# CITY OF ALBUQUERQUE

December 30, 2011

**Re: Gibson Apartments Grading and Drainage Plan  
No Stamp (L17-D024)**

Based upon the information provided in your submittal received 12-19-11, the above referenced plan cannot be approved for Building Permit until the following comments are addressed:

GRADING PLAN

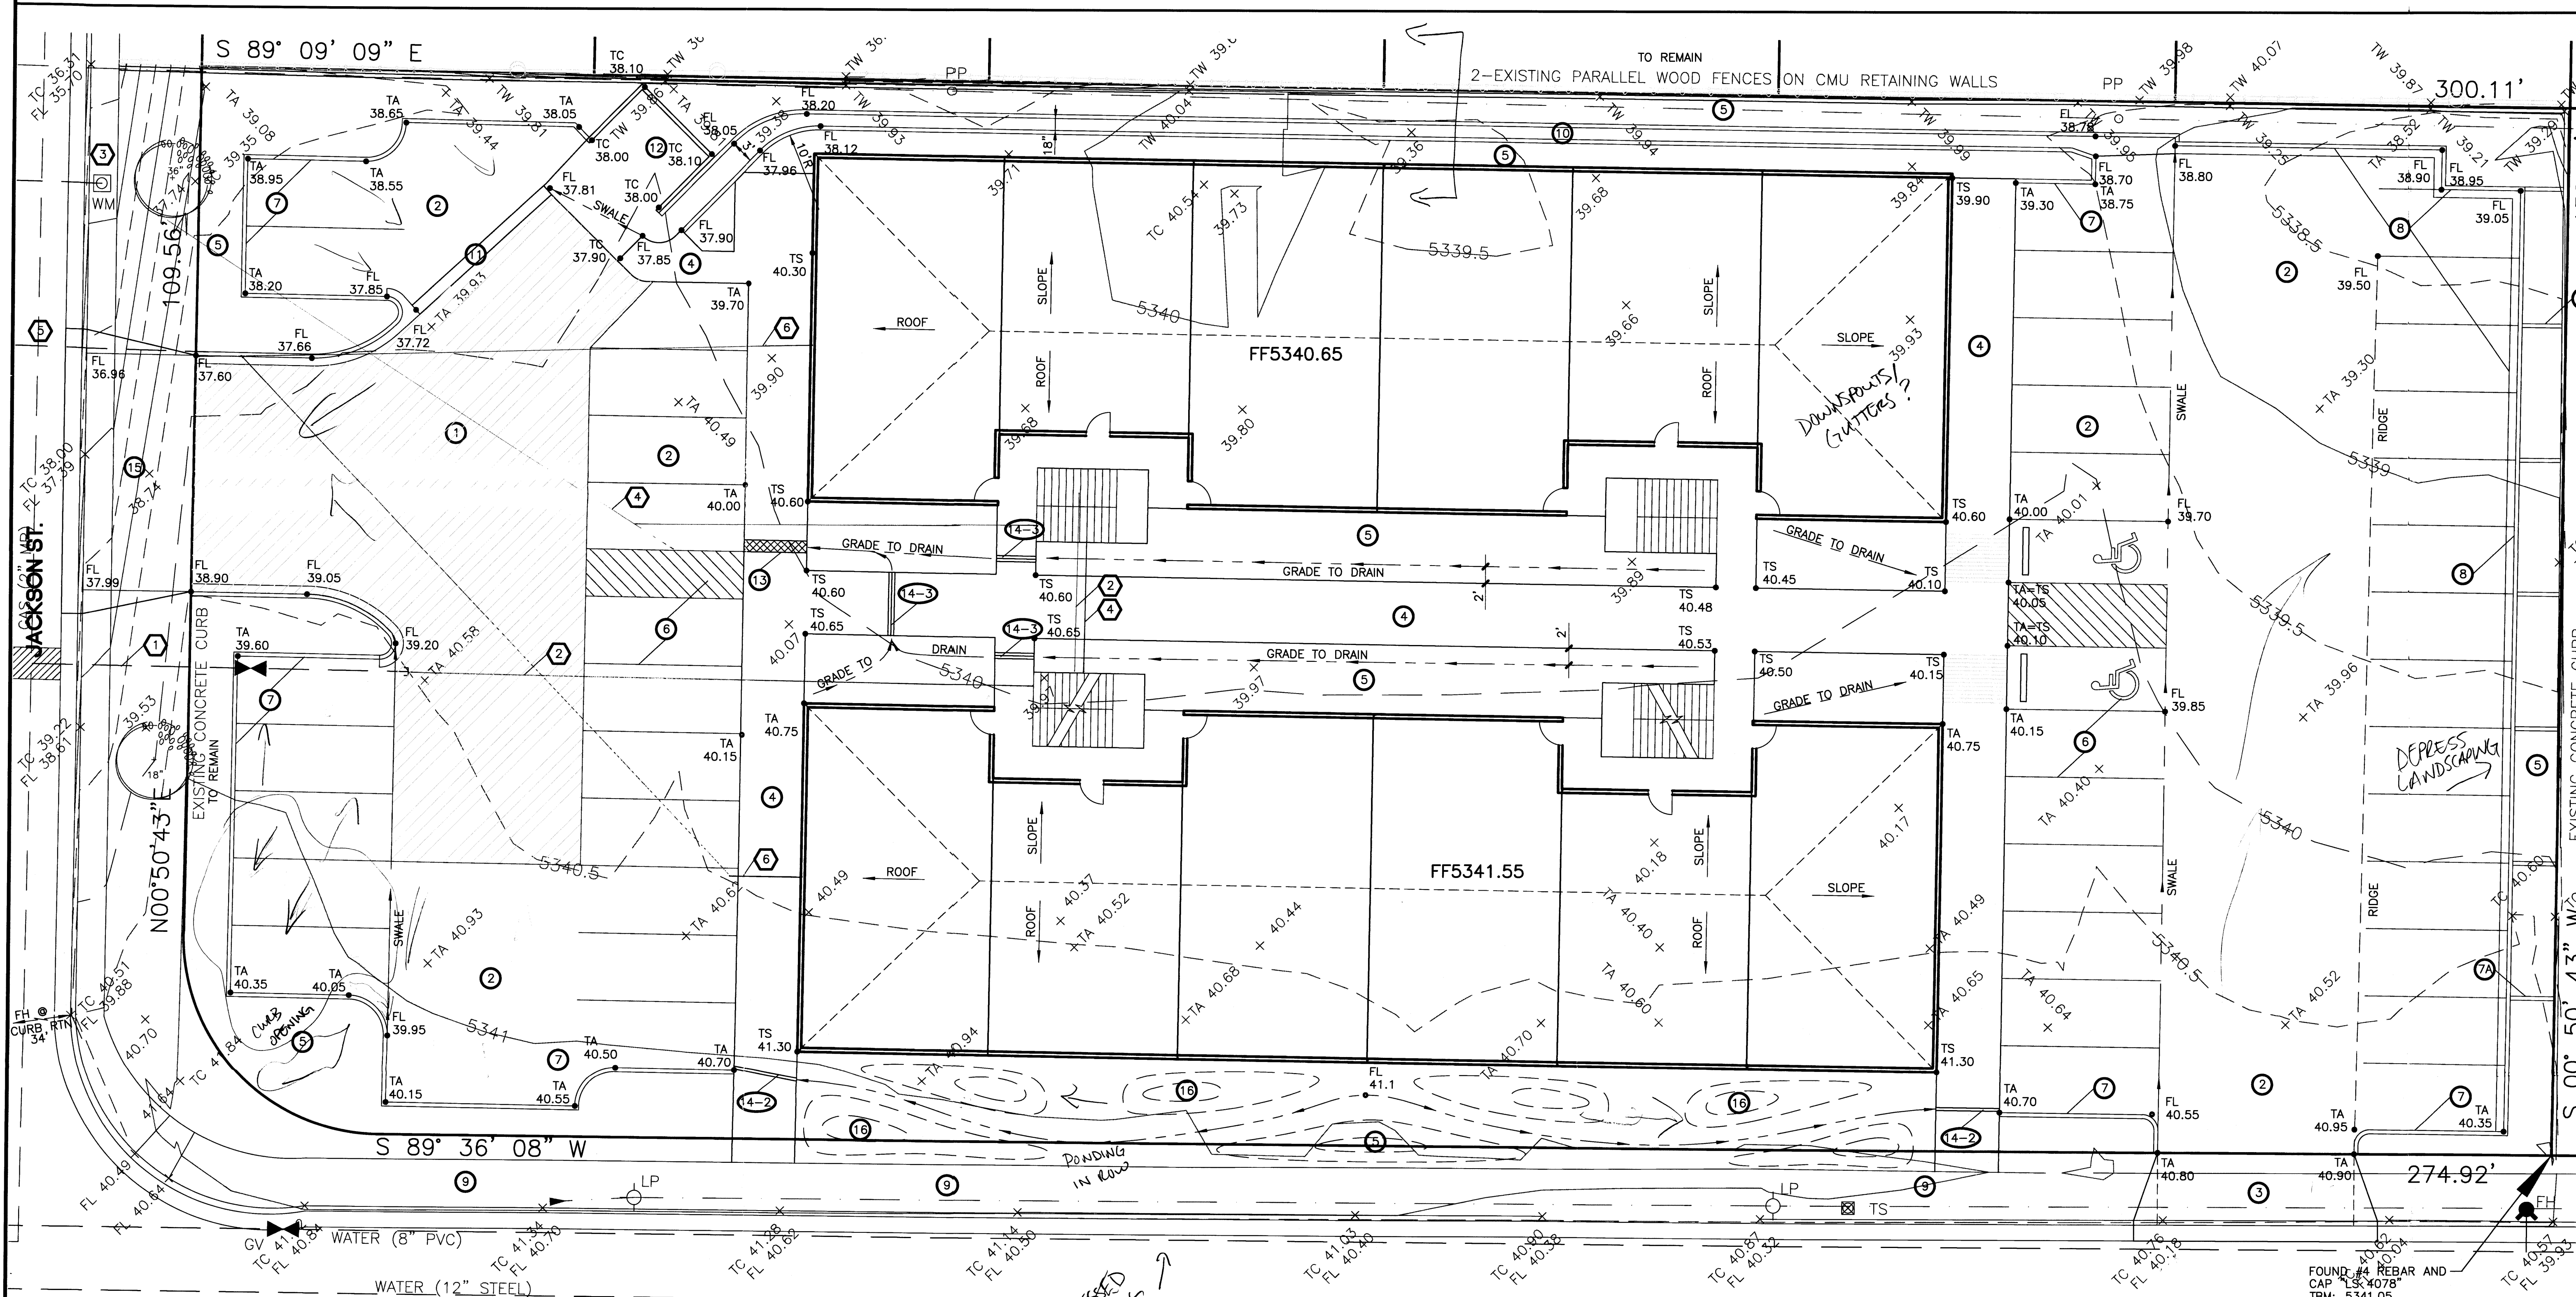
- The depressed landscaping on the southern edge of the property appears to encroach onto City of Albuquerque right-of-way.
- Hydrology requests that all landscape areas are depressed for water harvesting where possible.
- Plan must include a New Mexico licensed professional engineer's stamp and date.
